Our Ref: CM/72/21/DOC

Town & Country Planning Act 1990 (as amended)
Town and Country Planning (Development Management Procedure) (England) Order 2015
Approval of details reserved by condition imposed under CM/18/21/PL relating to conditions 5-
Biodiversity Enhancement plan, 7-covered and secure cycle storage, 8-electric vehicle charging
space(s), 9-Energy Statement, 10-surface water drainage, 11-Arboricutural Assessment & 12-
Construction Management Plan.
Mistletoe Farm Horsemere Green Lane Climping BN17 5QZ

Arun District Council have decided to **REFUSE** details reserved by condition for the following reasons:

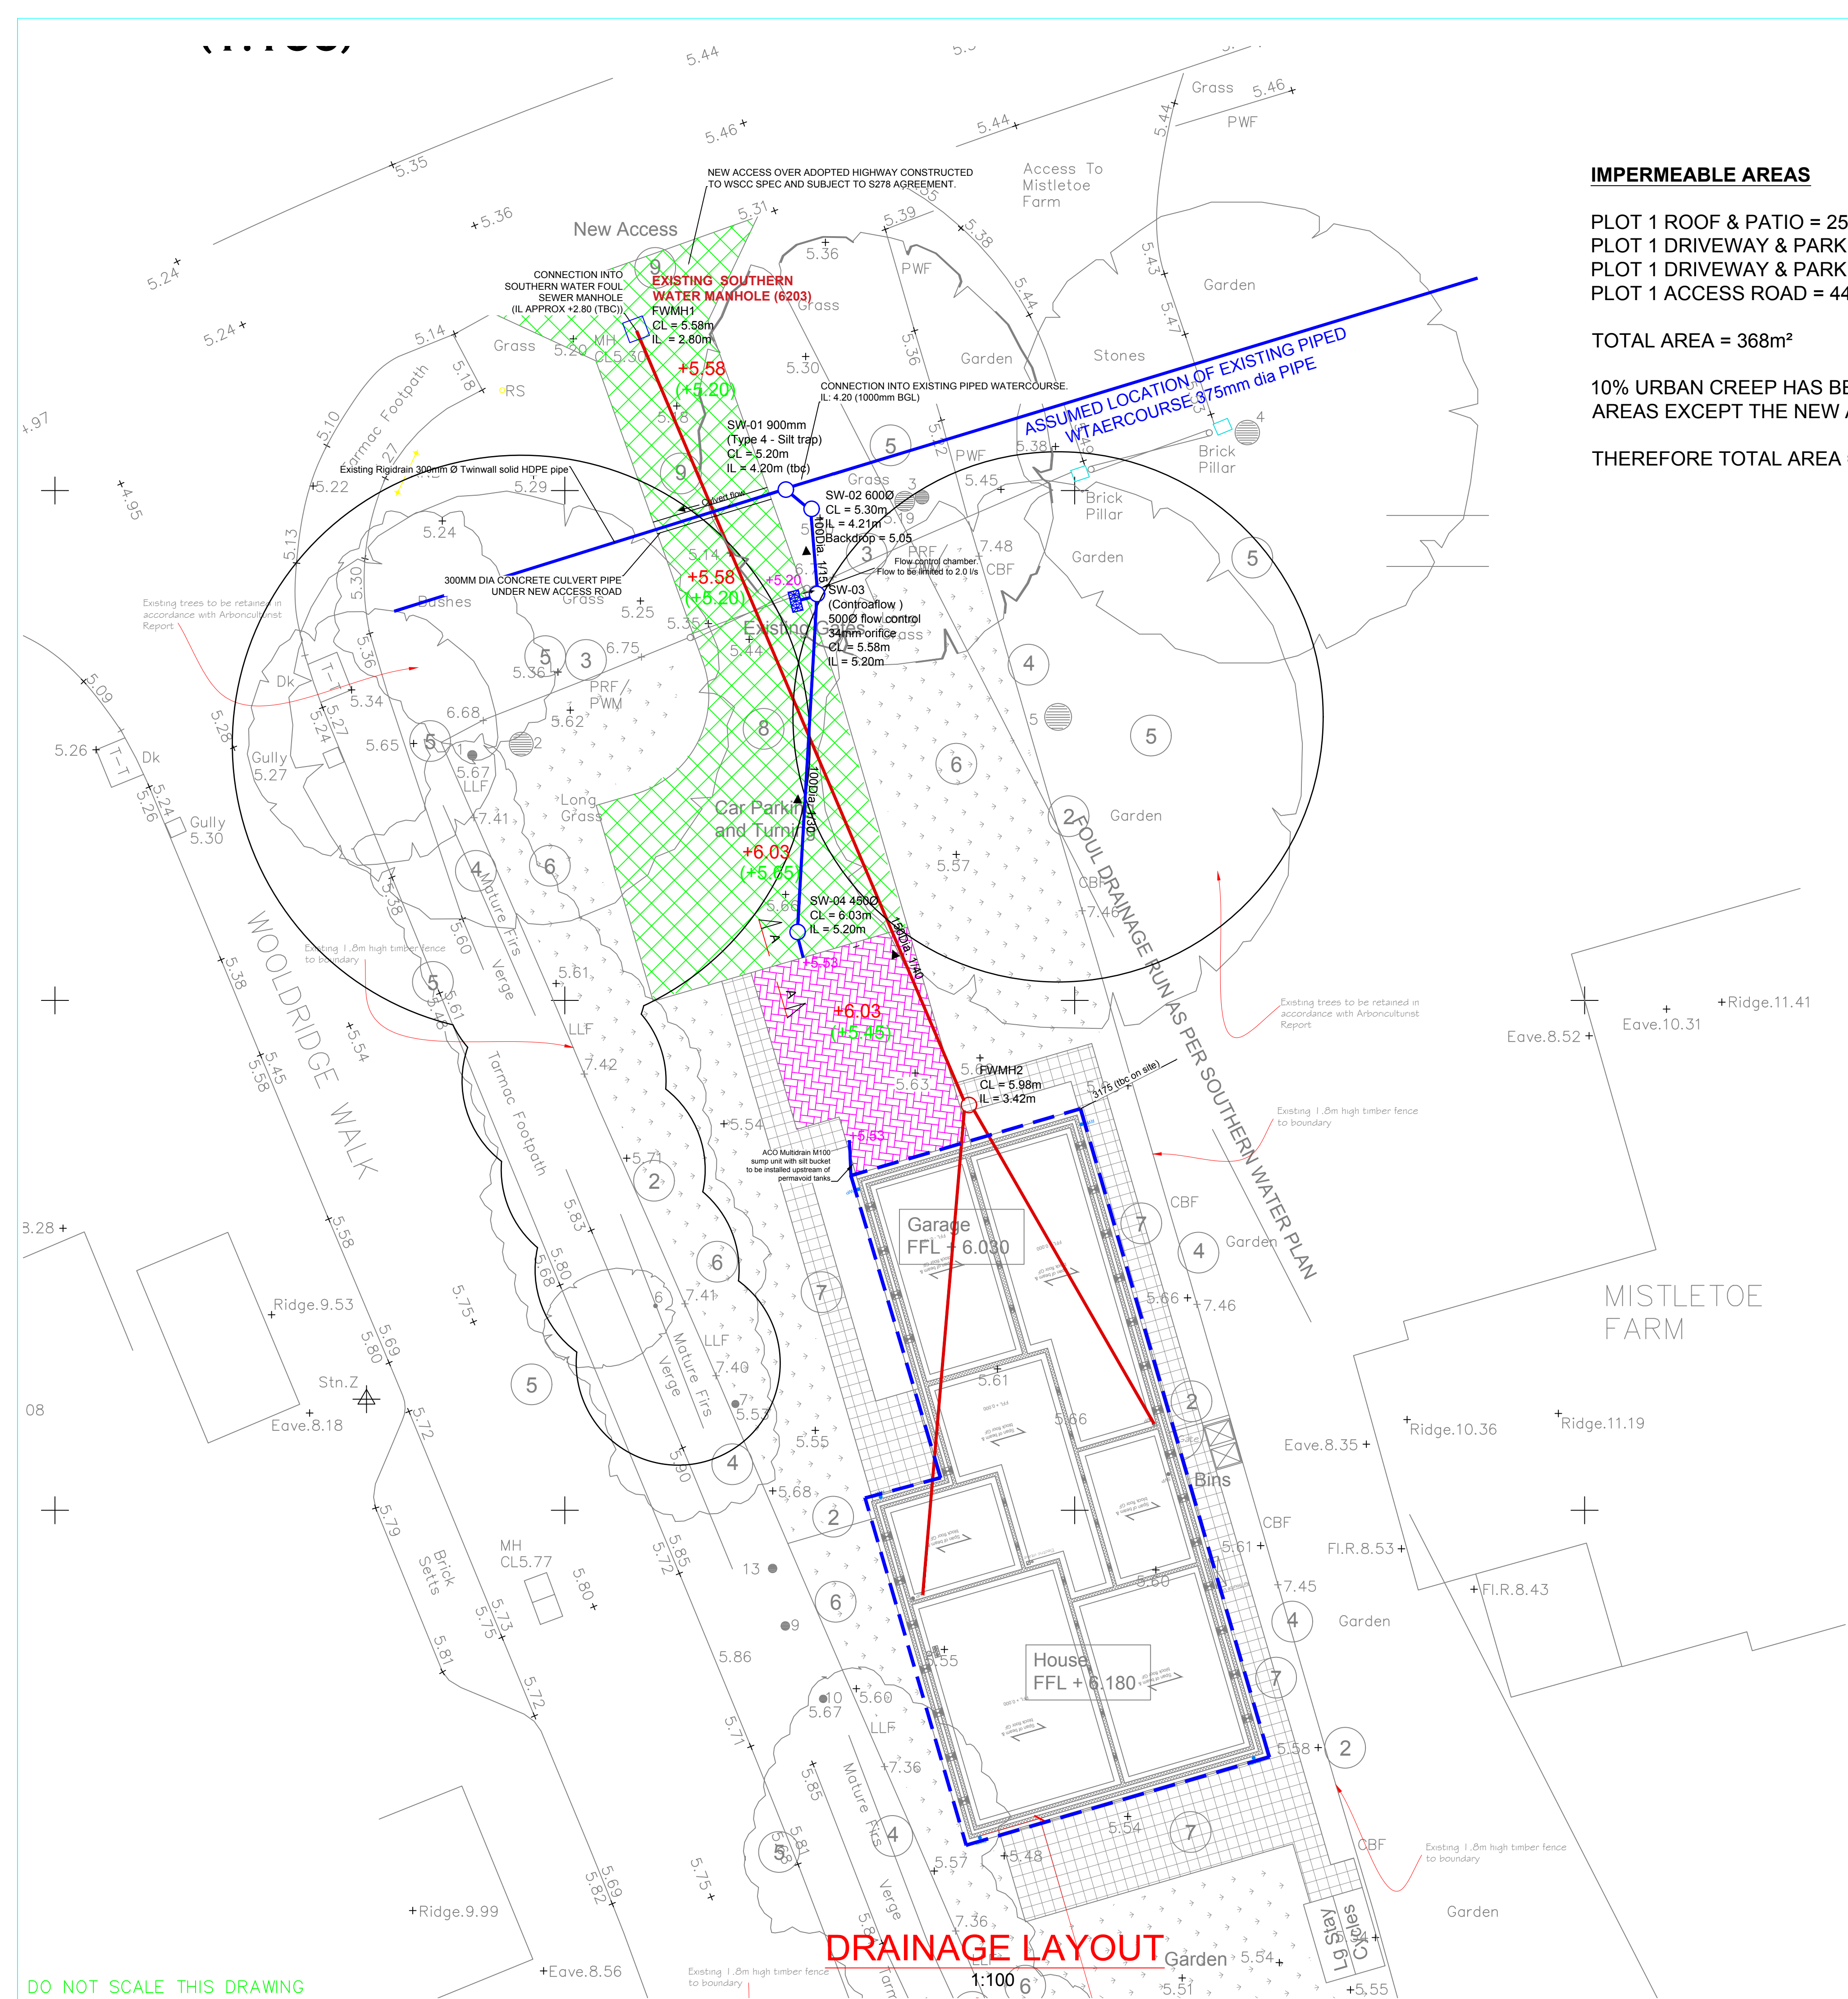
1. Following receipt of details labelled all pipes with diameter and fall, it is noted there is no fall present between SW04 and SW03. But considerable fall between SW03 and SW02, please provide minimum fall between SW04 and SW03. Note ACO multidrain around building with no fall, is there no way to design the RWPs to provide only downpipes to the north of the building and remove this feature?

**TYPICAL DETAIL SUMP MANHOLE TYPE 'A'
COVER LEVEL TO SOFFIT OF PIPE <1.500M**
SCALE 1:20

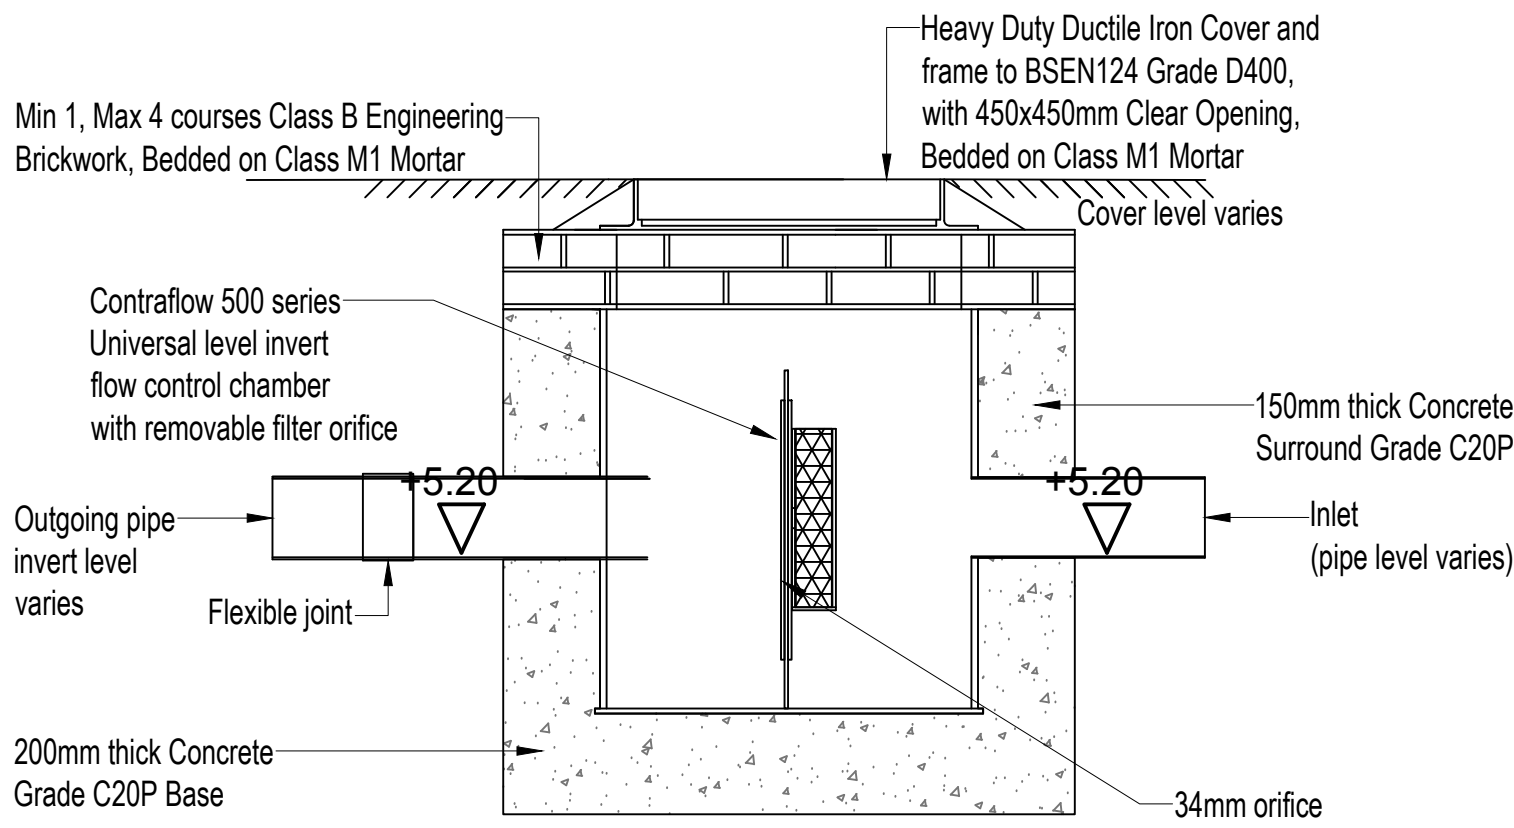
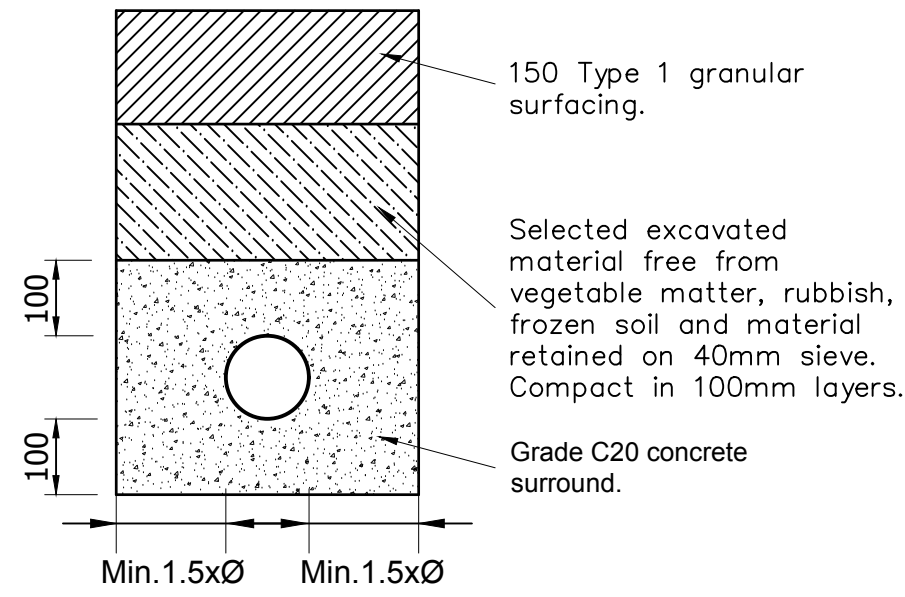
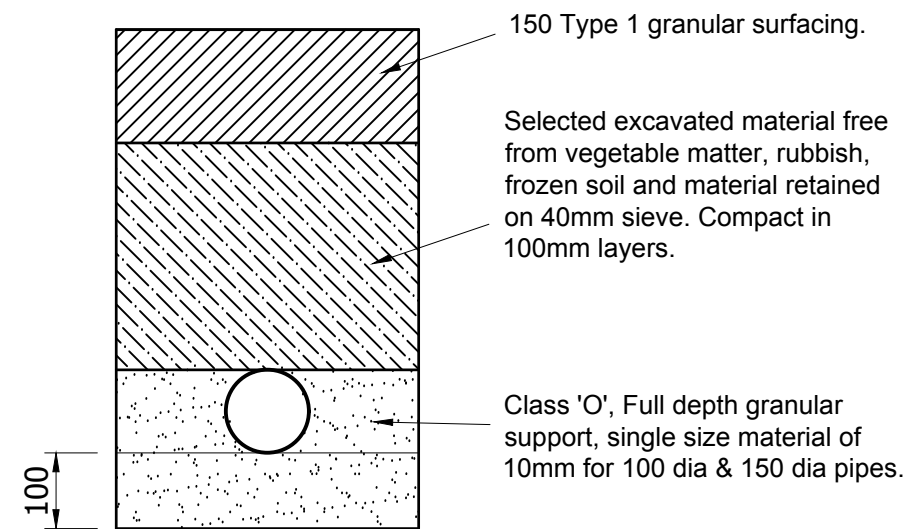
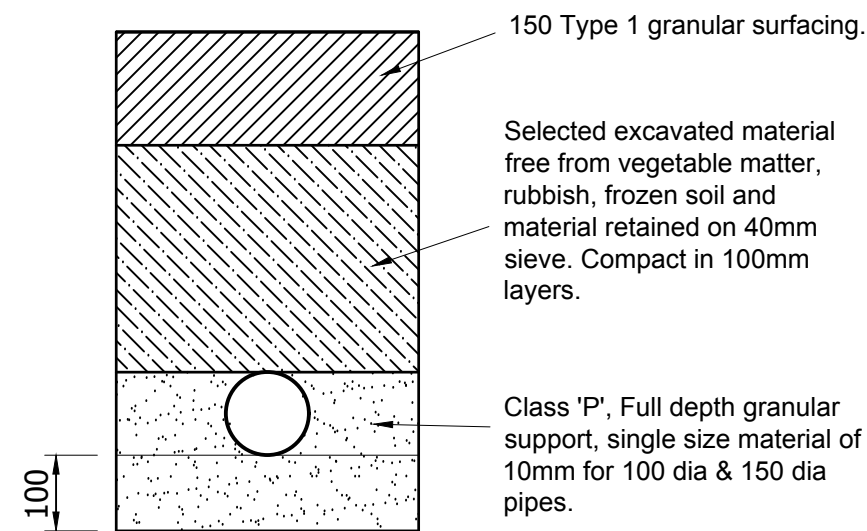
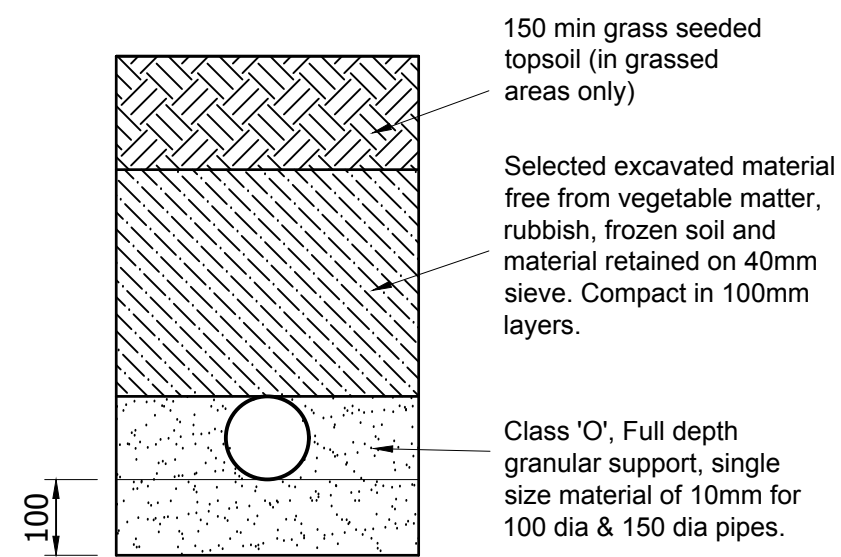
2. The submitted construction detail drawings of catchpits, pipe bed and surround, and hydrobrake are not acceptable. The catchpit detail is poor, e.g. benching should not be shown at pipe level, you are implying that the chamber extends below the internal base rather than there being a sump. Sump depth shown to base of in situ concrete foundation needs correction.

CONTROFLOW FLOW CONTROL CHAMBER DETAIL
SCALE 1:15

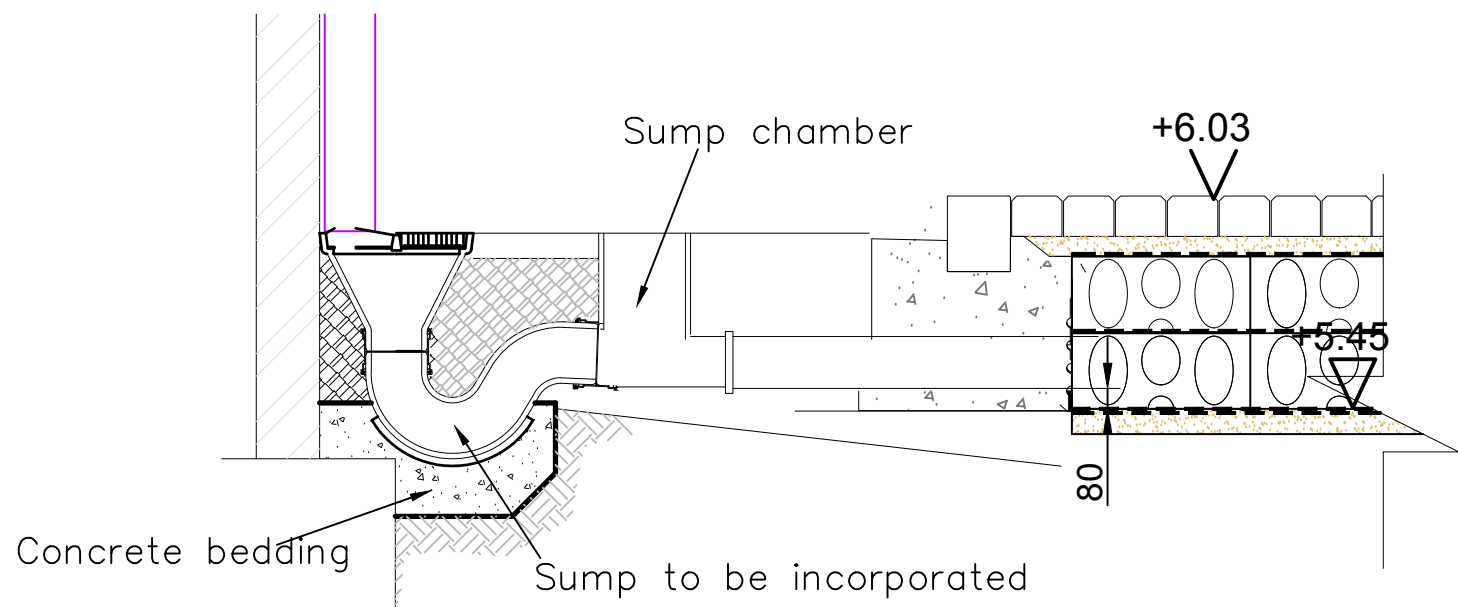
11. Calculations do not demonstrate the required head specification for the hydrobrake - It is noted you have opted for Controflow with orifice. See comment 1 above which may result in change to SW03 invert level. Provision of Controflow data to evidence orifice size and level are suitable is required.
